Transport  
for NSW

TfNSW Reference: SYD21/01257/03

**ROOTY HILL MATERIALS RECYCLING FACILITY  
600 WOODSTOCK AVENUE, ROOTY HILLS (SSD-29999239)**

1 SITE / GROUND FLOOR
1:400

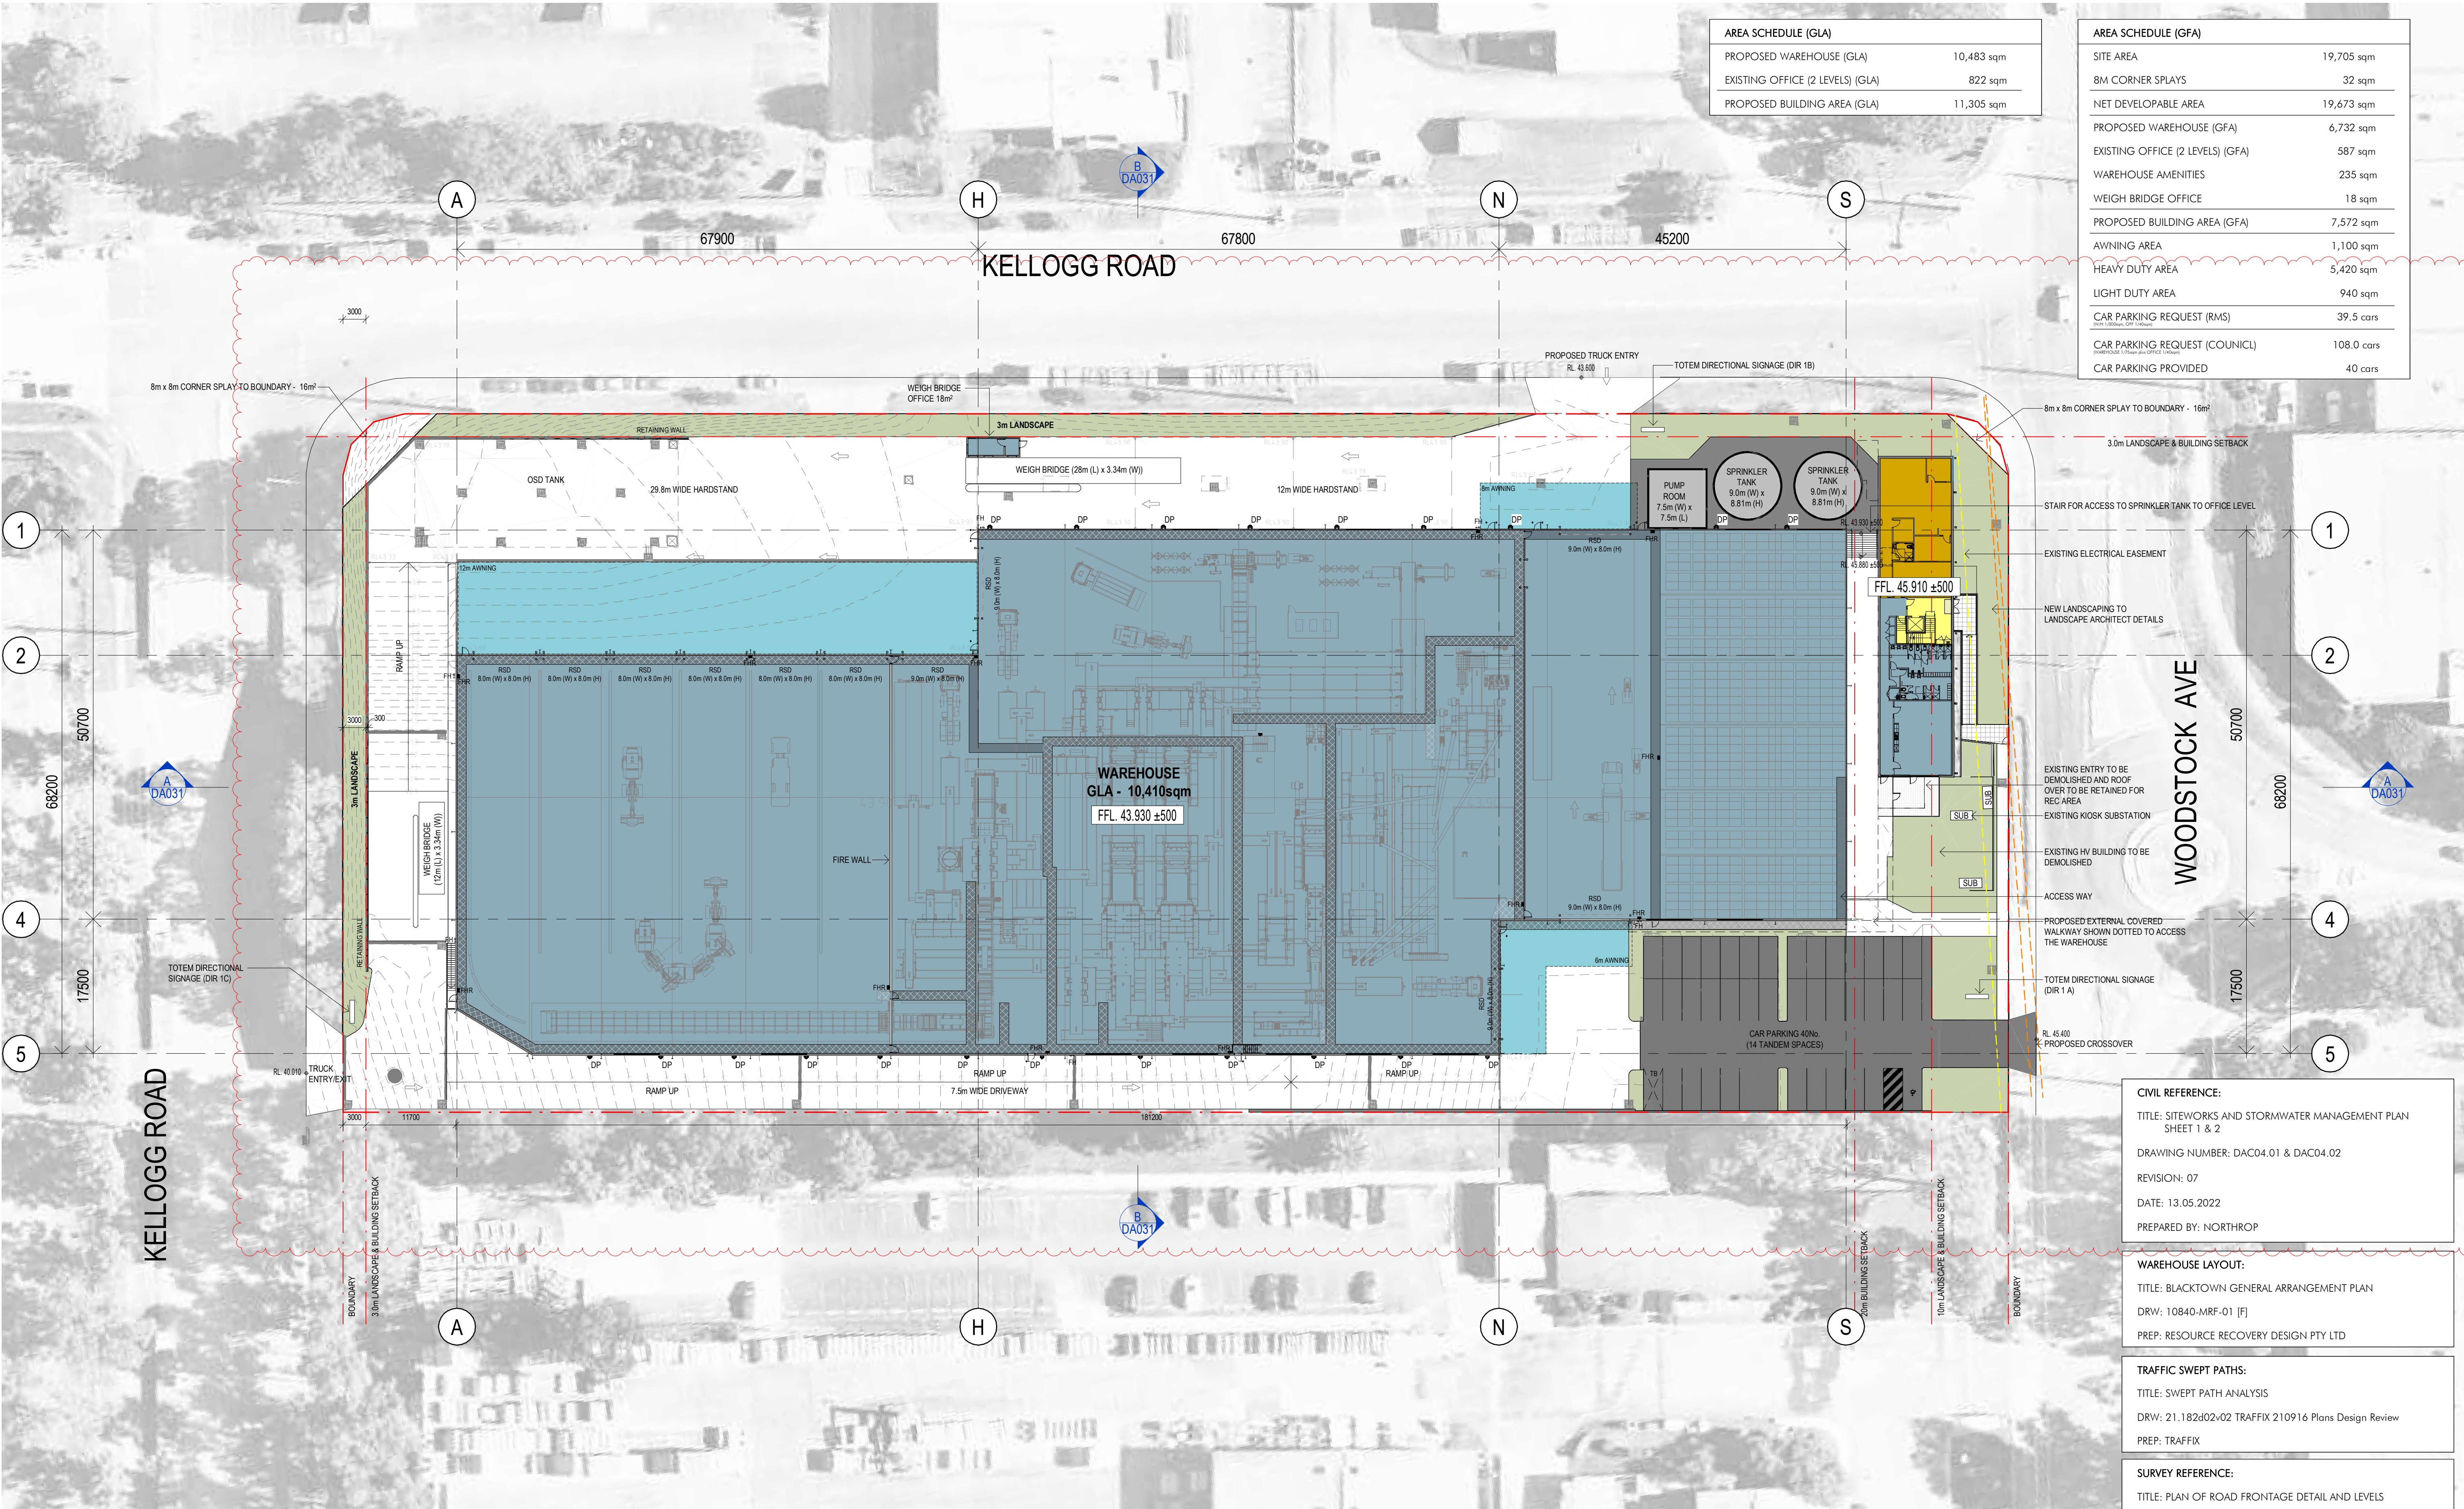
The existing driveway in close proximity to the roundabout should be removed to eliminate dangerous vehicle movements, noting the location of the (existing) driveway encourages vehicles accessing the site in a forward direction across the roundabout, as opposed to a left turn from Woodstock Avenue. TfNSW requests the application be amended to address this concern ensuring safety, and be submitted to TfNSW for review.
